A1 Birtley to Coal House
Scheme Number: TR010031
Applicant's Response to Deadline 8

Applicant's Response to Deadline 8 Submissions

Rule Number:	Rule 8(1)(c)
Planning Inspectorate Scheme Reference	TR010031
Application Document Reference	Applicant's Response to Deadline 8 Submissions
Author:	A1 Birtley to Coal House Project Team, Highways England

Version	Date	Status of Version
Rev 0	8 July 2020	For Issue

Drawing Number	Originator	Volume	Revision
HE551462	WSP	6.3	P06

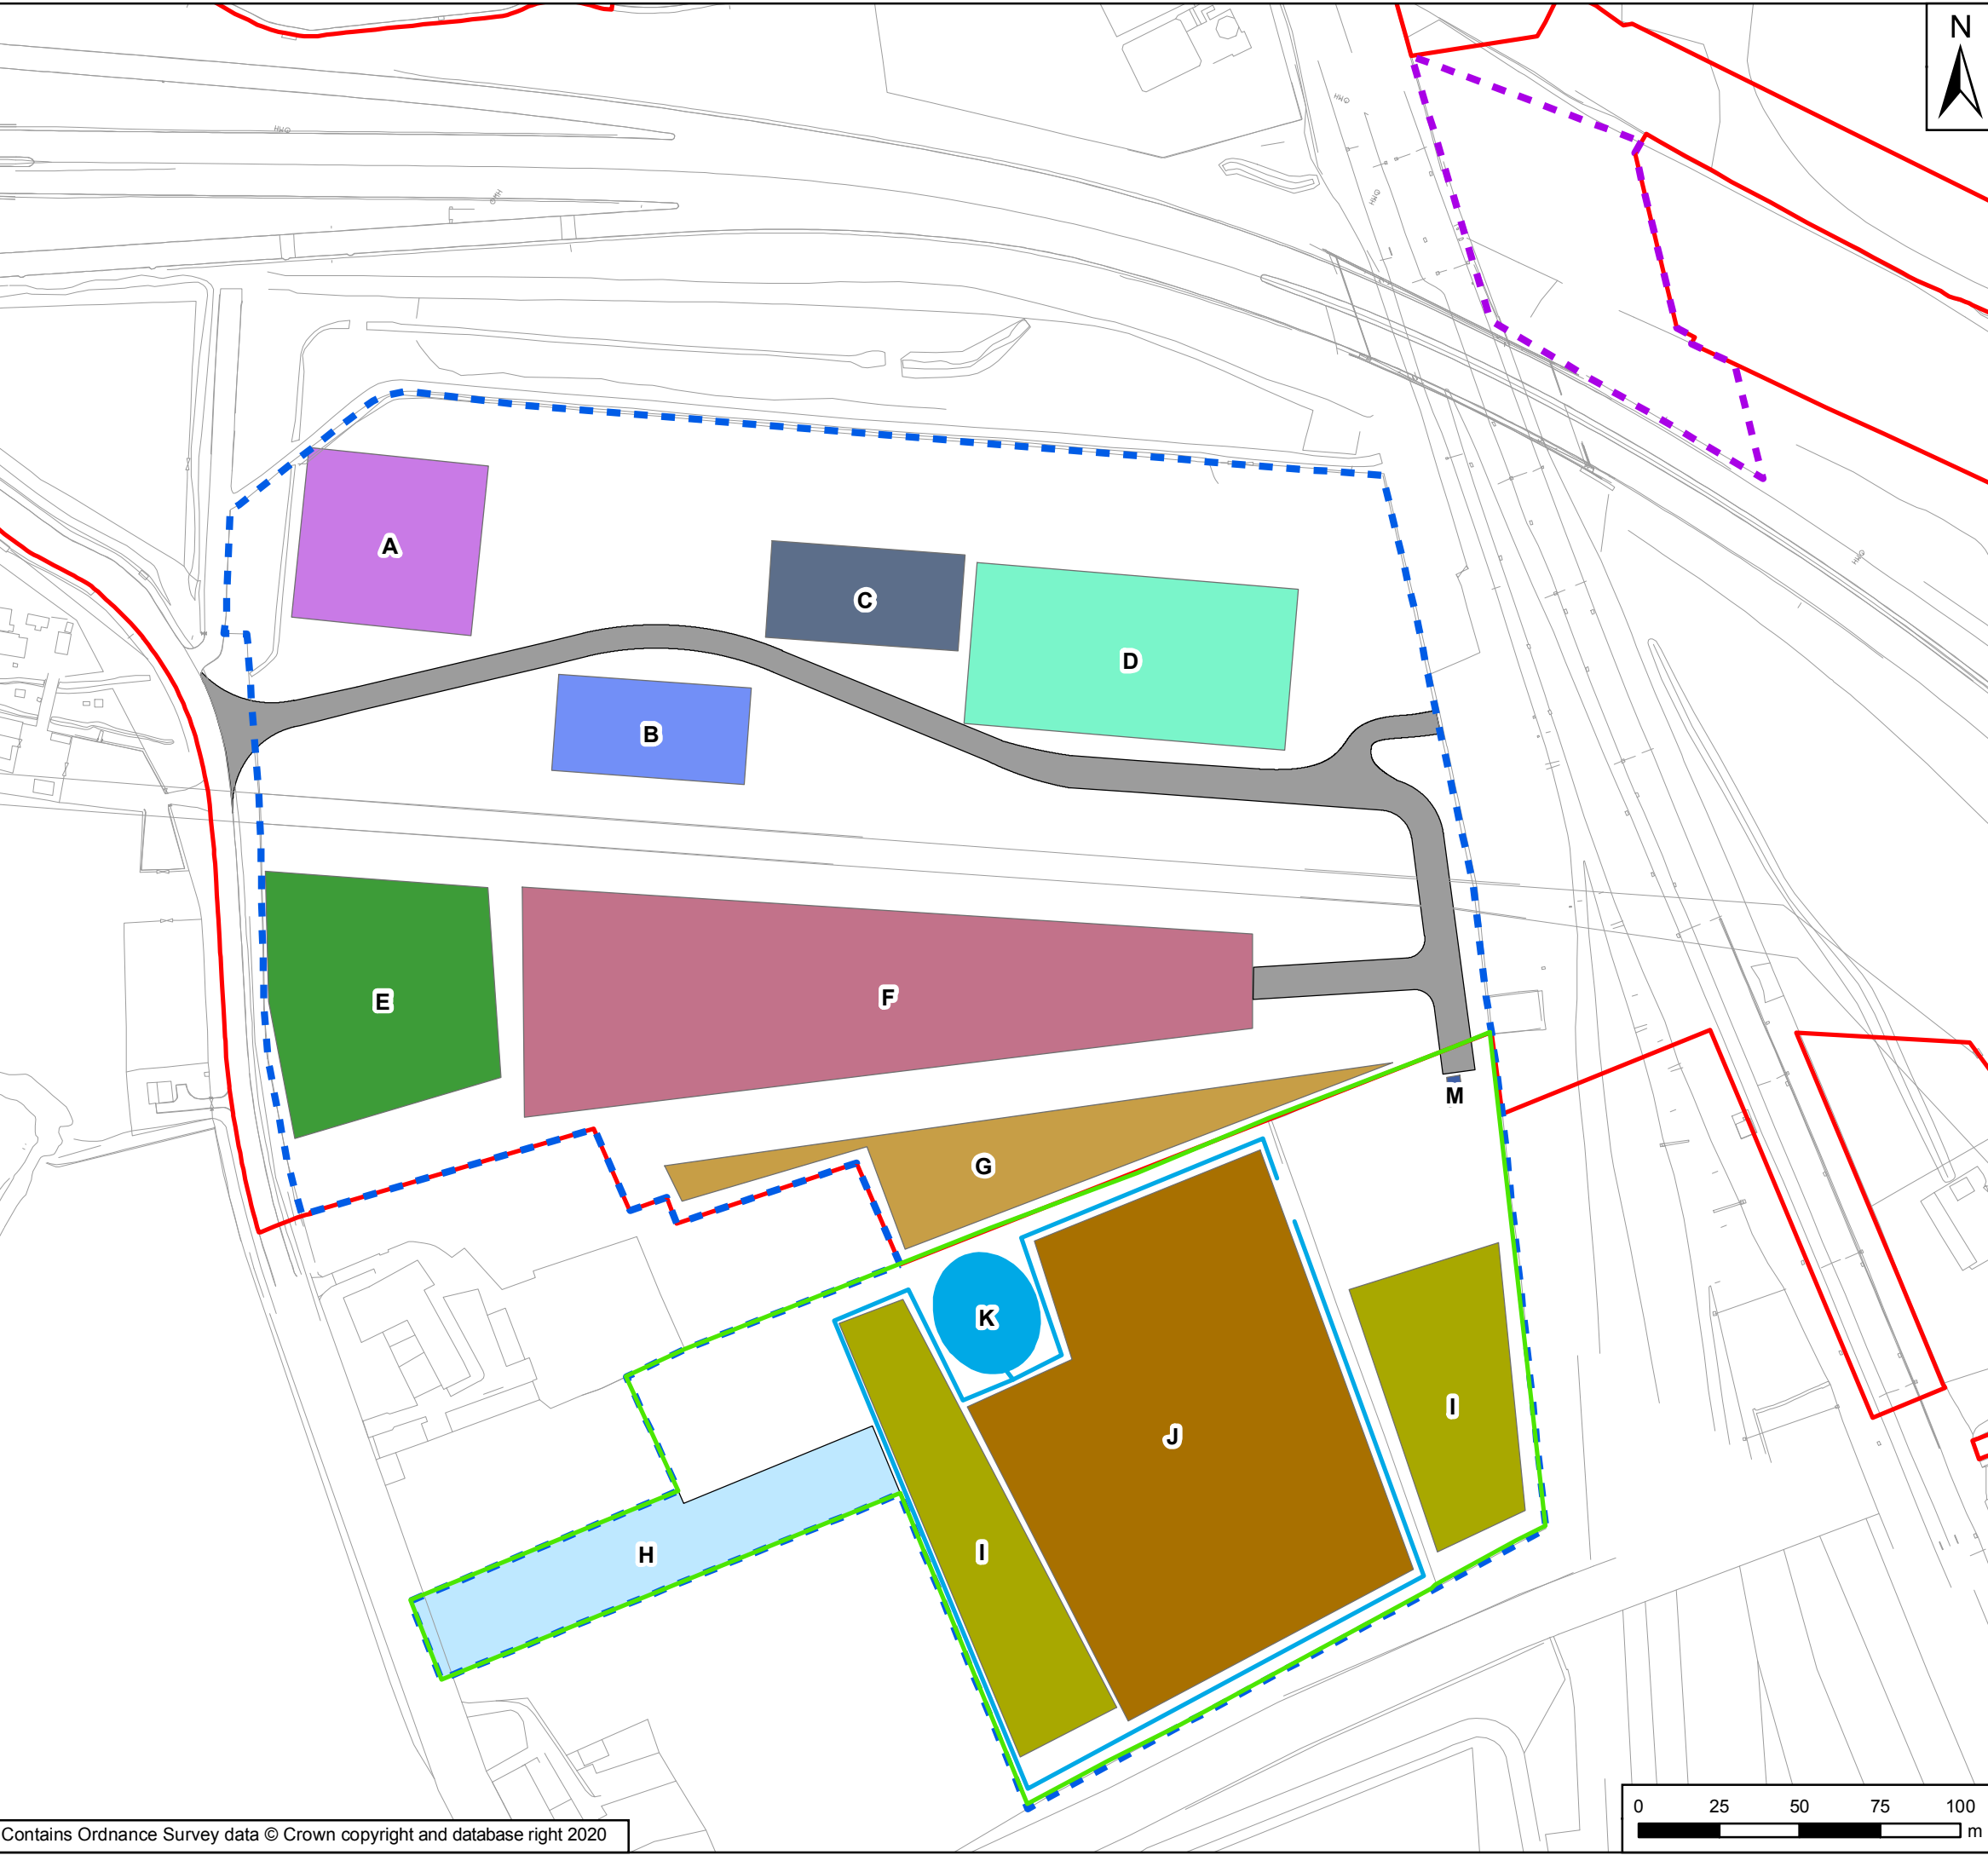
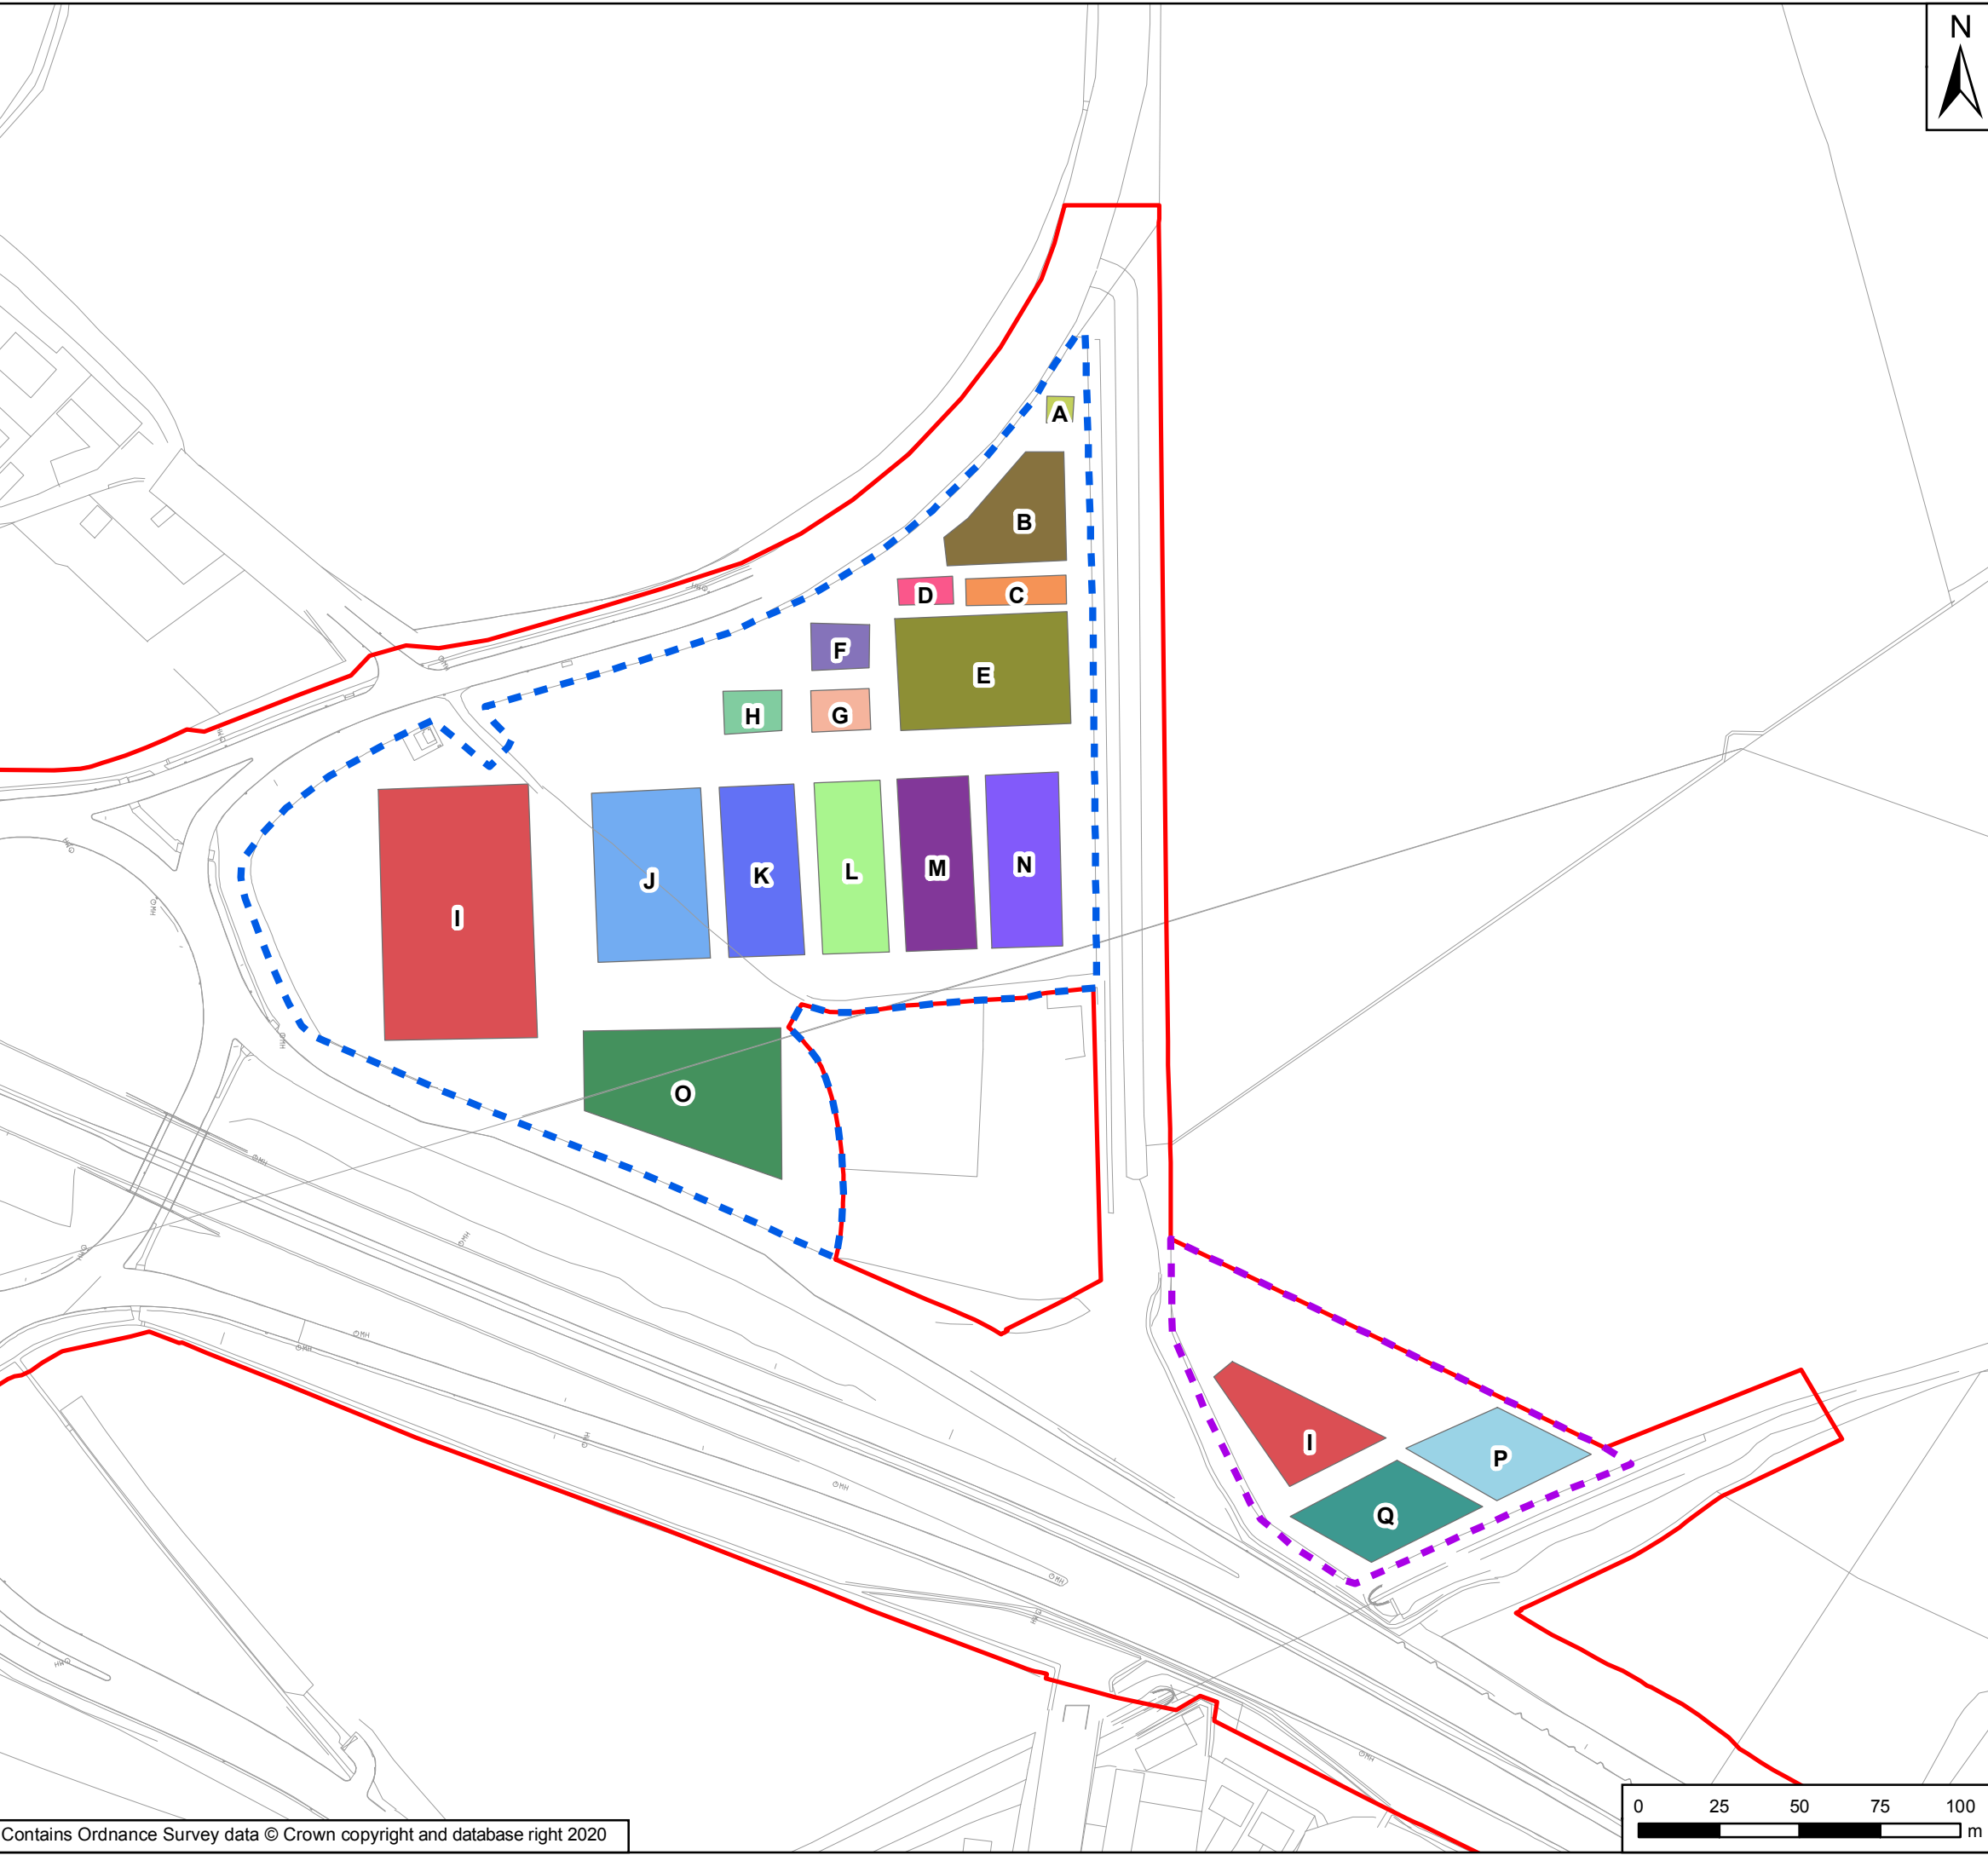
Ref No:	Gateshead Council's Response:	Applicant's Response:
3.0.1	The Council considers that the final details of the compounds should be secured for approval through the final CEMP to help ensure impacts upon the Green Belt, biodiversity and amenity are kept to a minimum. This could be done by referencing them under requirement 4 (2).	As detailed in the Applicant's response to the ExA's third written questions [REP8-024] WQ 3.0.1, a new action [G12] has been added to the Outline Construction Environmental Management Plan (CEMP) [REP8-007 and 008], as follows: <i>"The final proposed layout of the construction compounds to be sited at Junction 67 (Coal House) and Eighton Lodge will be included in the CEMP and must be in substantial accordance with the layouts shown on Appendix A - Figure 1/AL Site Compound Plan of the Outline CEMP. Where parcel 3/13a is included in the powers granted by the made DCO, the layout of the construction compound to be sited at Junction 67 (Coal House) shall be in substantial accordance with the image in Figure 1/AL Site Compound Plan Detailed View, Junction 67 (Additional Land)."</i>
